Application Reference: 2026/0425

Site Address: 11 Hardwick Grove, Dodworth, Barnsley, S75 3SS

Introduction: Erection of front and side boundary wall (Retrospective)

Drawing Title.
**PLANS & ELEVATIONS
AS BUILT**

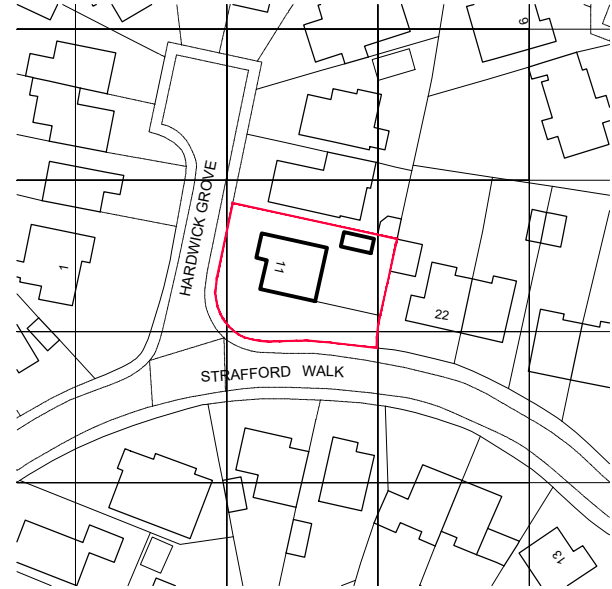
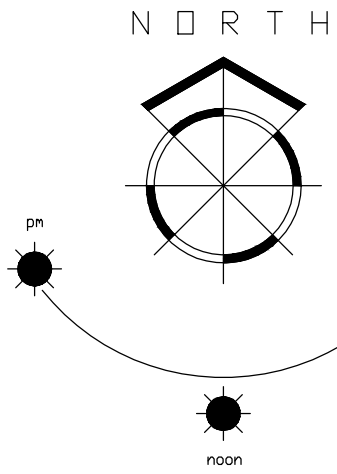
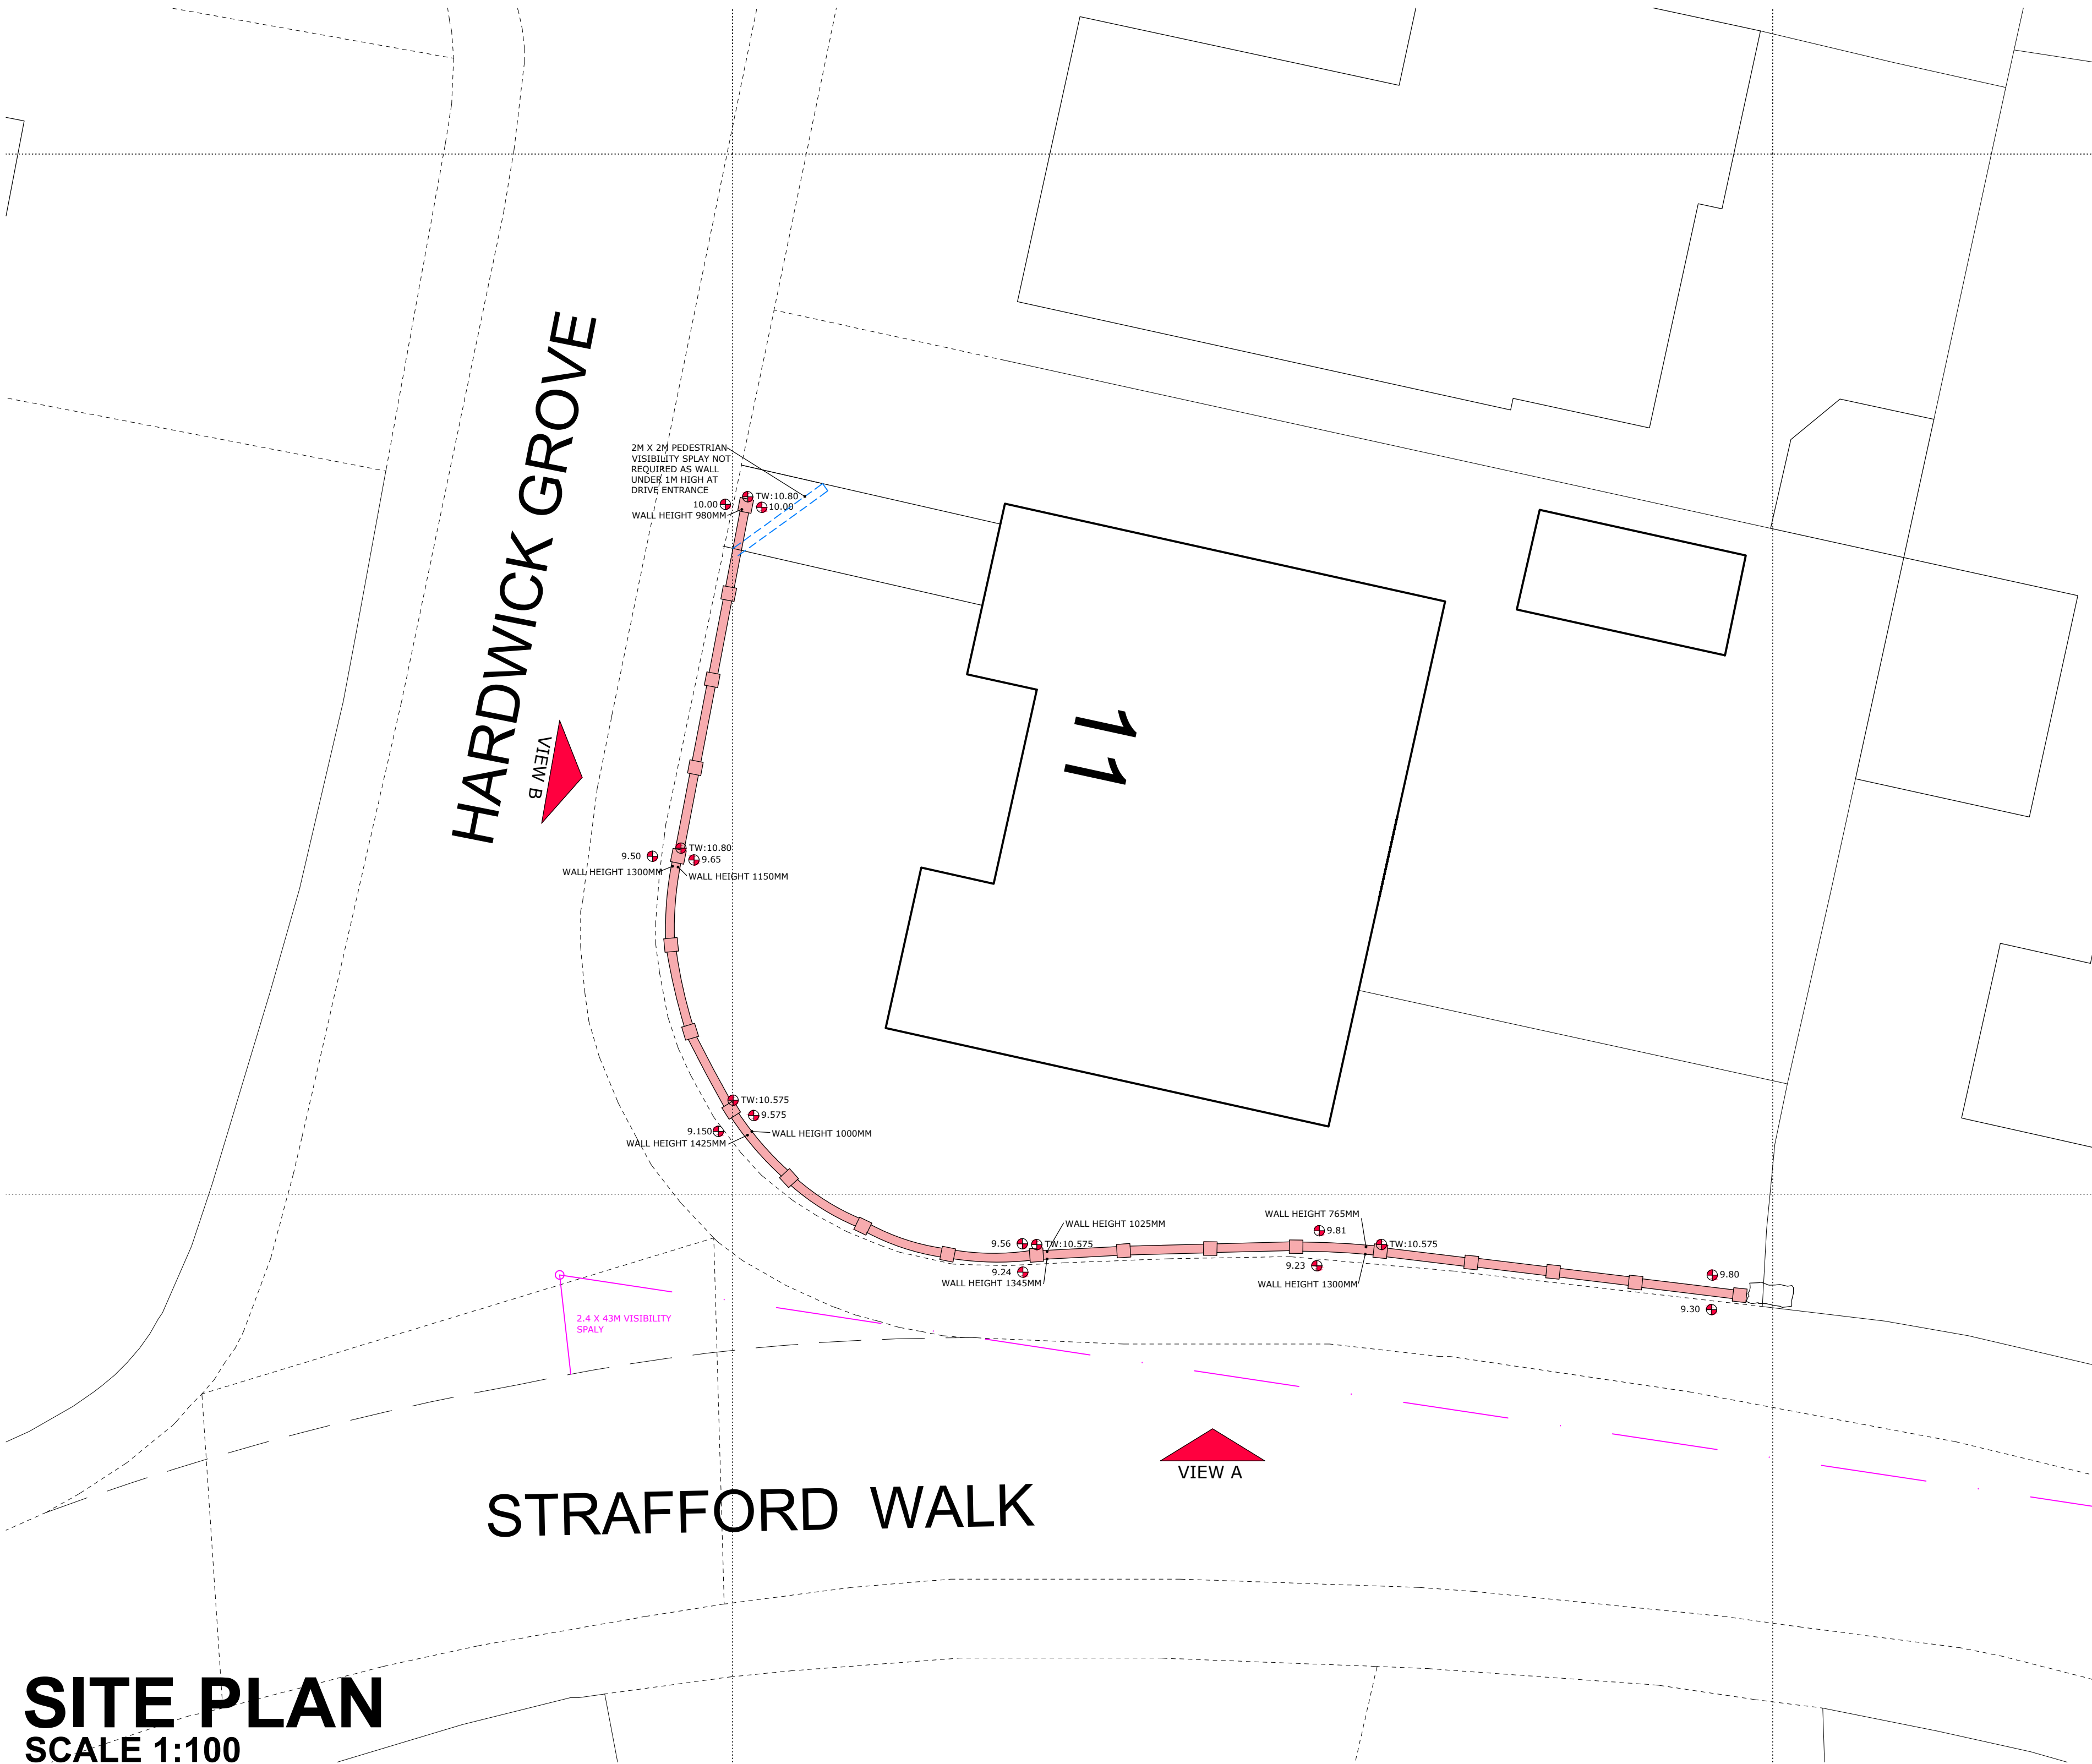
It is acknowledged the initial west elevation of the boundary wall leading from the driveway measures approximately 1 metre in height and is therefore considered permitted development. This element of the wall is therefore considered acceptable. The wall quickly exceeds 1 metre in height as the topography of the site and the highway falls towards the south of the site leading onto Strafford Walk. The height of the wall reaches approximately 1.5 metres in height on the southwest boundary of the site before being stepped down to approximately 1.3 metres for the remainder of the wall.

The 1.5 metre height of the wall is not considered to relate to the character of the area and street scene. The street scene is characterised by either no walls or low level walls with some railing features which are acknowledged to exceed the height of 1 metre, however given they are railings, offer little dominance in the streetscene. Tall bushes and hedges are acknowledged to be within the street scene, however cannot be considered as they do not constitute built development. It is therefore apparent that the predominant character of the street scene is low level non-dominant boundary treatment or no boundary treatment. The proposed boundary wall is therefore contrary to the character of the street scene and the Walls and Fences SPD.

The proposed wall is located in a prominent location within the streetscene of Hardwick Grove and particularly prominent on Strafford Walk. The height of the wall in a prominent location therefore plays a significant role within the street scene and the excessive height is considered considerably visually dominant, incongruous within the streetscene, and detracts from the character of the area. Although the wall is acknowledged to have been proposed to be reduced to 1.3 metres, on the whole, the wall height remains excessive and would detract from the character of the street scene.

It has been necessary to make contact with the applicant to request plans and elevations which provide a scheme in line with the Walls and Fences SPD with a maximum wall height measured externally to the road of 1 metre. The applicant has partially reduced the wall through amended plans and elevations received on the 6th July 2026. The amendments were not considered acceptable as the height of the wall was not reduced down to what has been requested and what is considered acceptable in line with the Walls and Fences SPD. Amendments were requested again but no amendments were received.
